Amended Concept Development Application (SSD-9579) for an Over Station Development (OSD) above the new Crows Nest Metro Station including maximum building envelopes, gross floor area, conceptual land uses, car spaces and signage zones.

Submission by Wollstonecraft Precinct Committee (Preliminary)

2.1.8 A-L07/08 Tower Transfer and Residential Floor

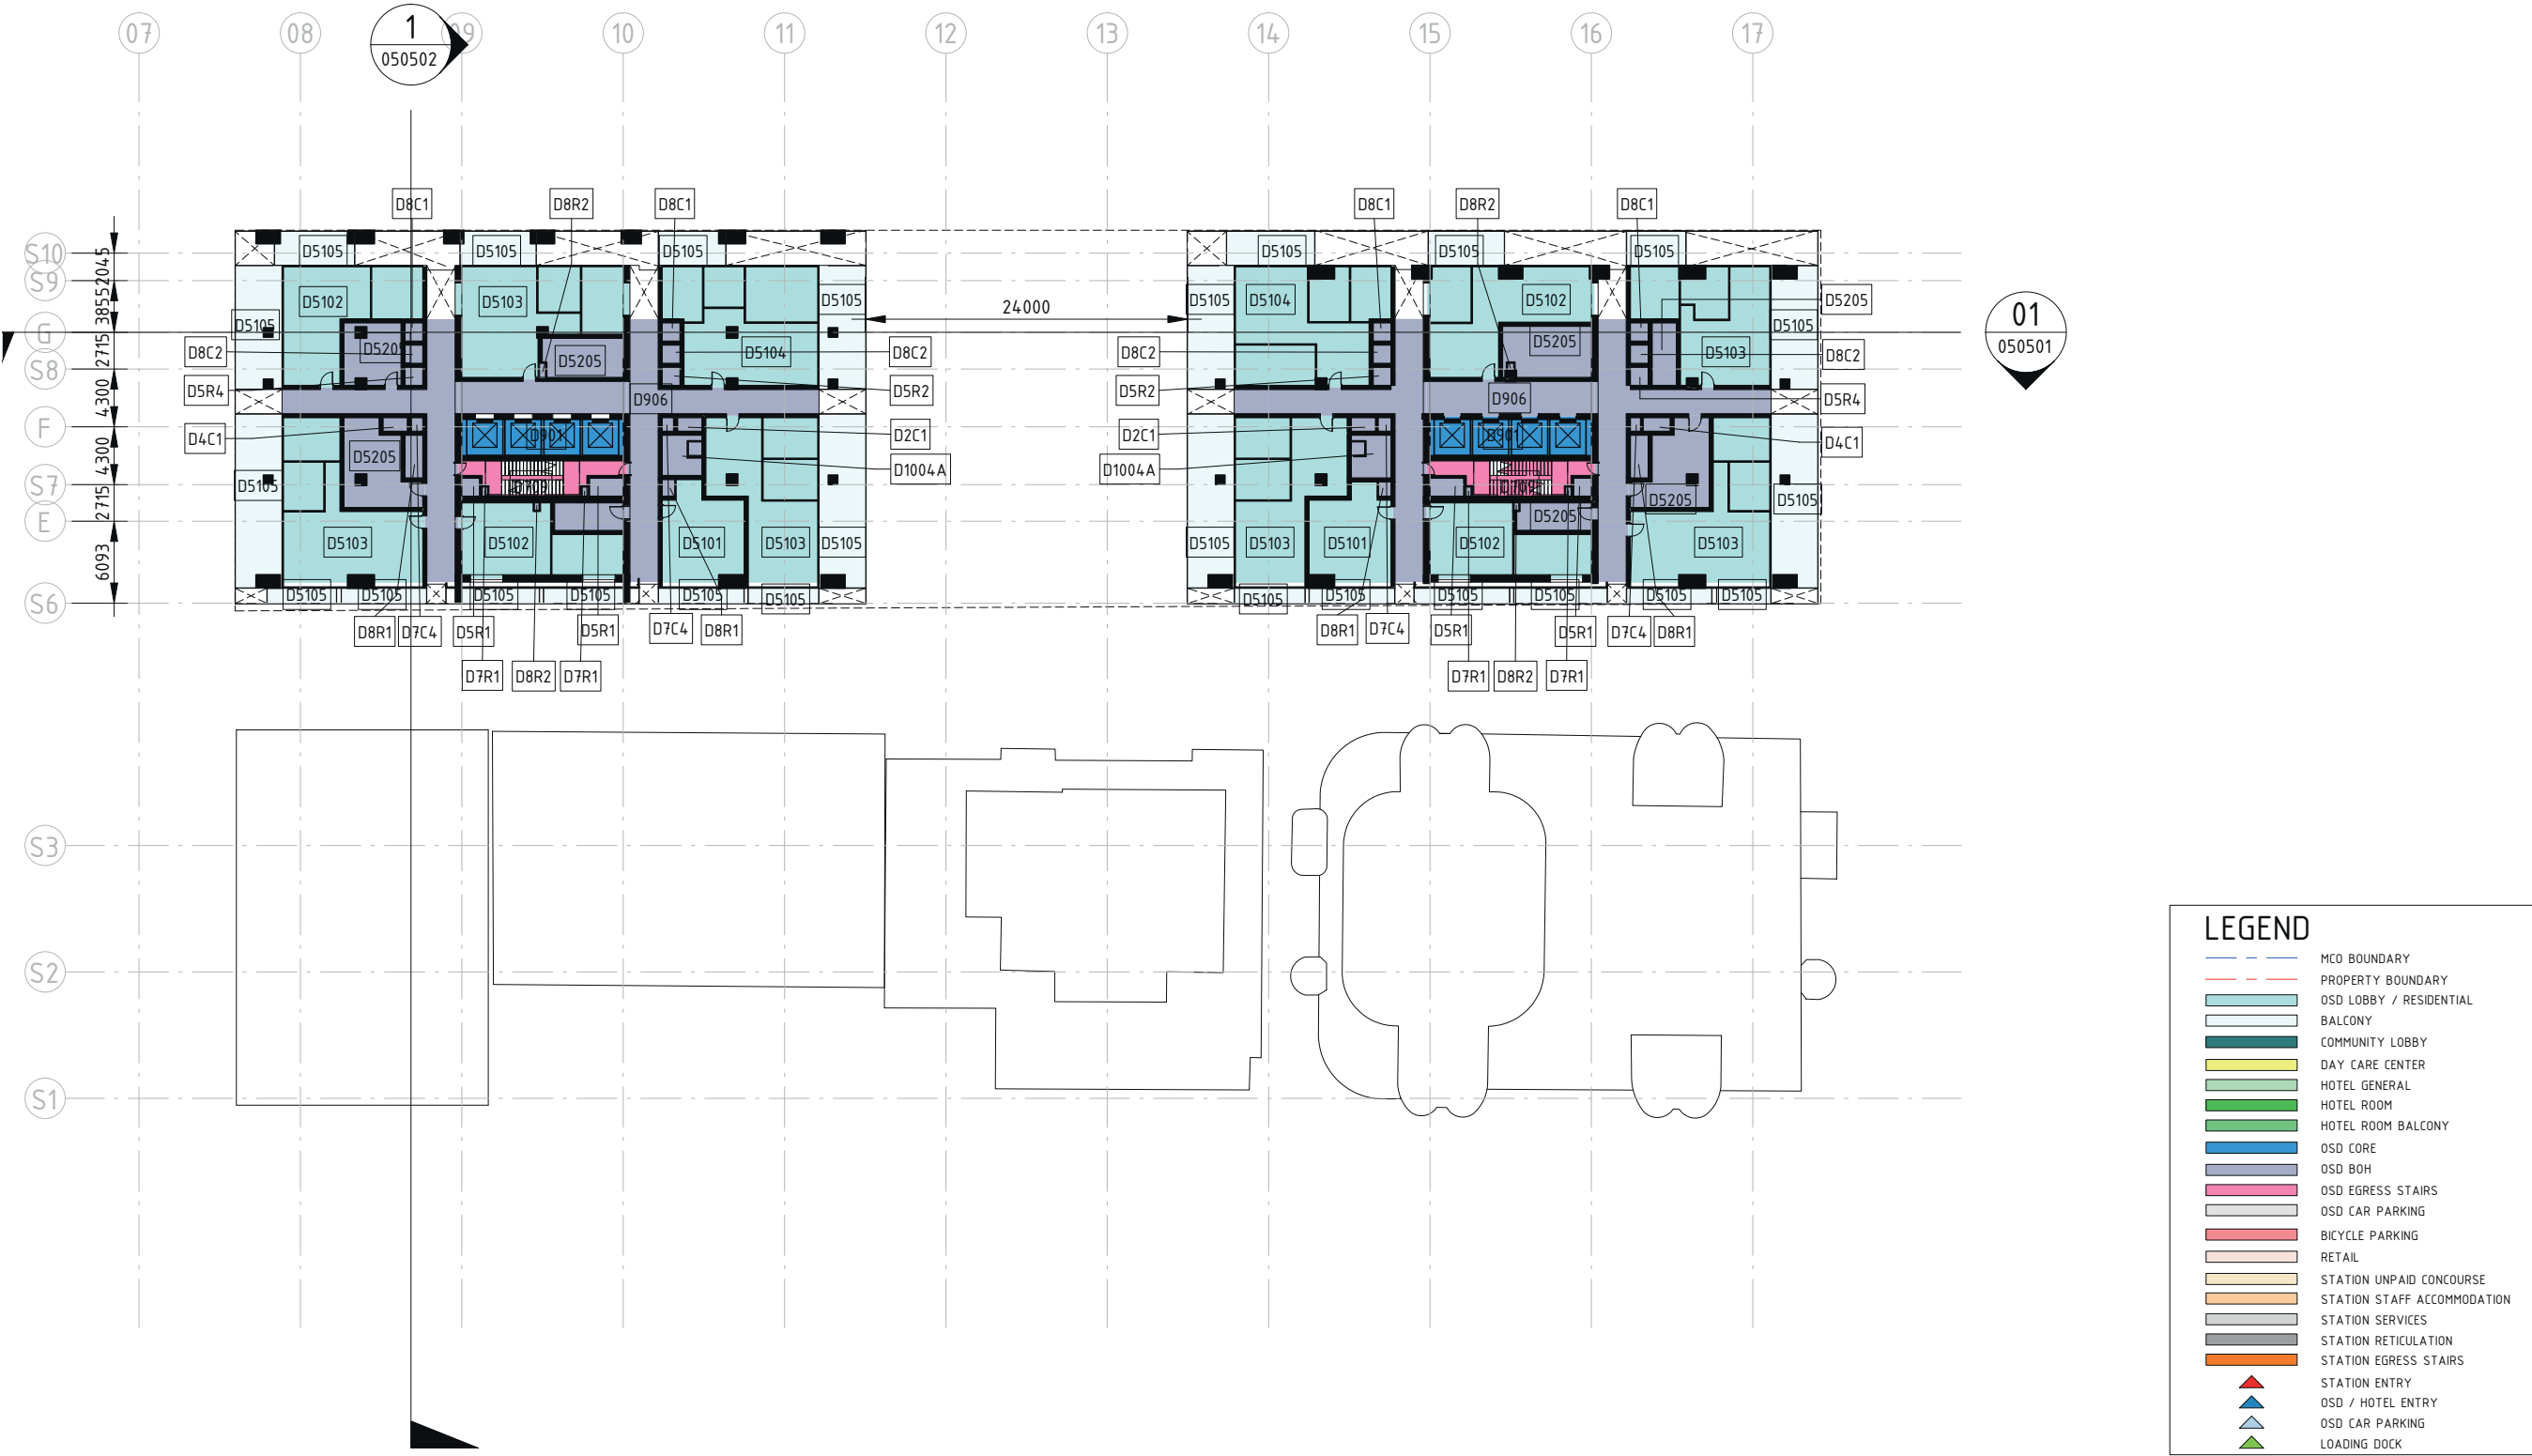
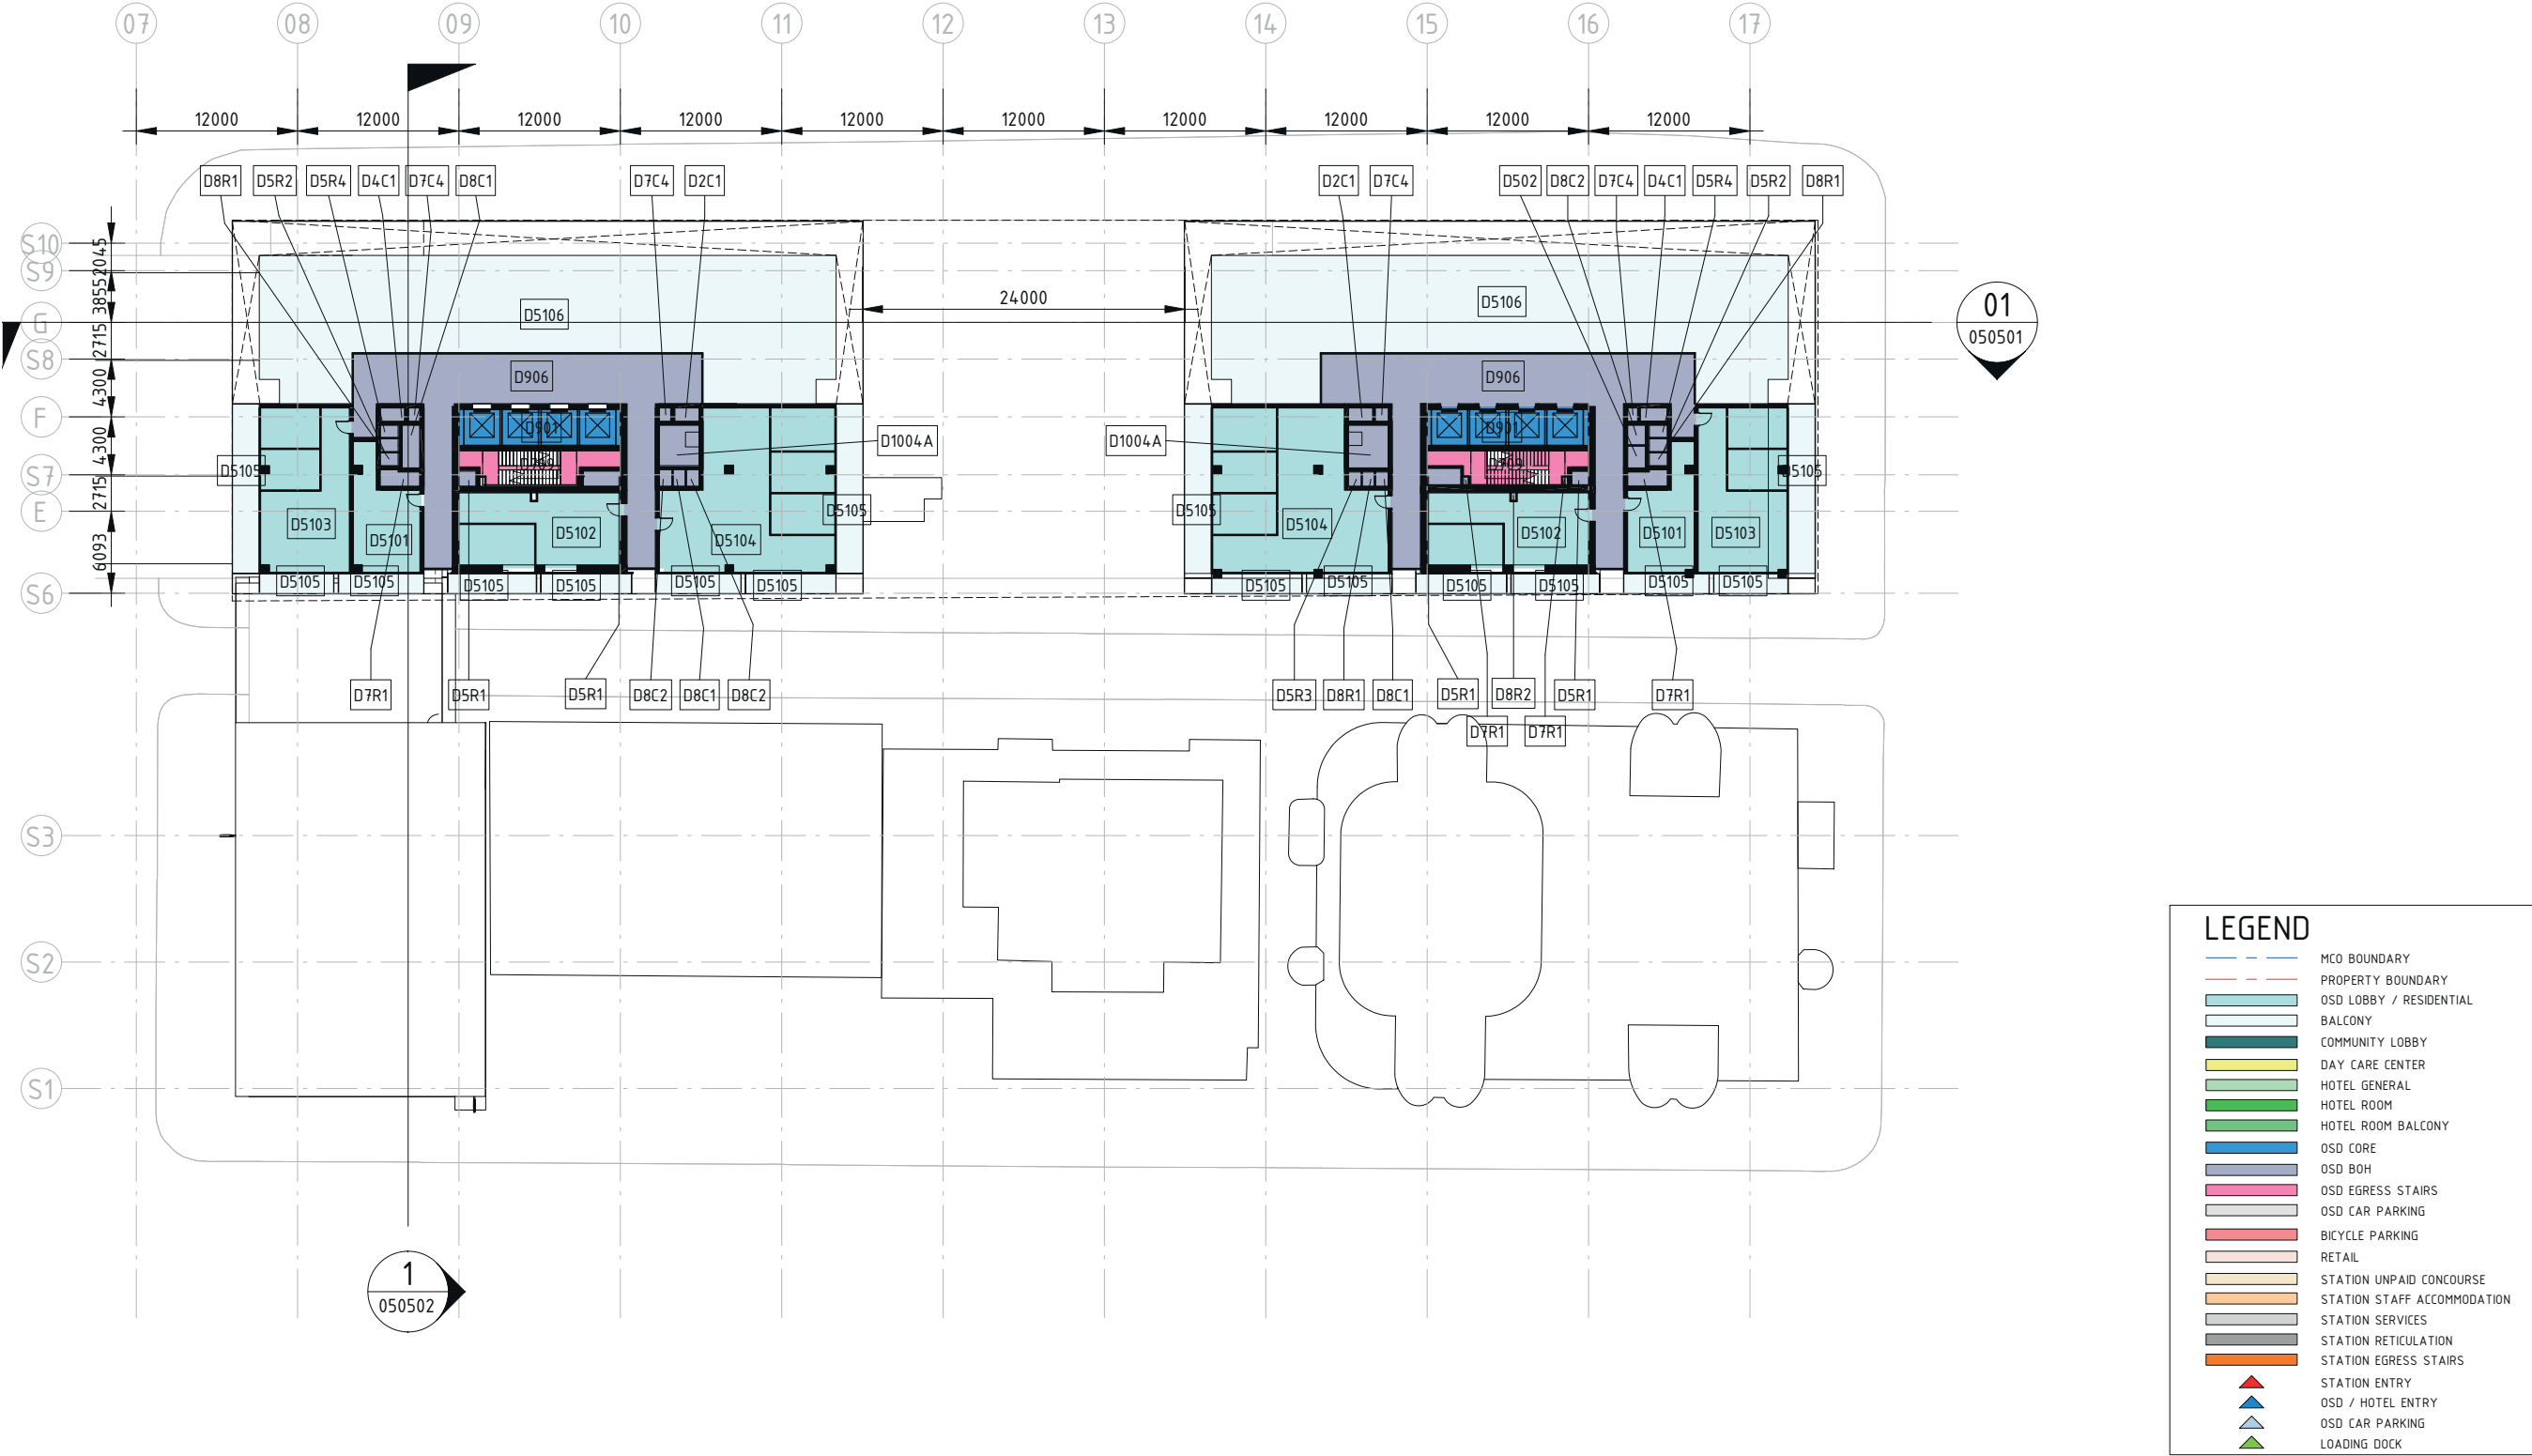
The response from Sydney Metro results in overdevelopment of Site A.

Conclusion: The amount of office space being provided by Sydney Metro is about twice as much as needed for Crows Nest and therefore Building A should be drastically reduced in height leading to less floor space. This would help reduce the over shadowing of the Crows Nest Village which has been ignored in the extensive analysis that has narrowed consideration to only over shadowing on Willoughby road, Ernest Place and Hume St Park. The solution of Sydney Metro to build a massive amount of office space is dated and pre-Covid. Commercial office space demand is and will remain depressed for decades. A better solution would be to both reduce height and also have the government fund job creation initiatives - a recommendation of its own consultants in the draft SLCN 2036 plan.

It is the OSD specifically on Site A and Site B that are contrary to the village atmosphere. Increased bulk and scale with heights to RL180 and RL155 can never be described as being in context with the village. They are just too high and bulky, looking like a box plonked atop the otherwise attractive new entrance to the village. Site C office building above the station eastern entrance makes no sense at all.
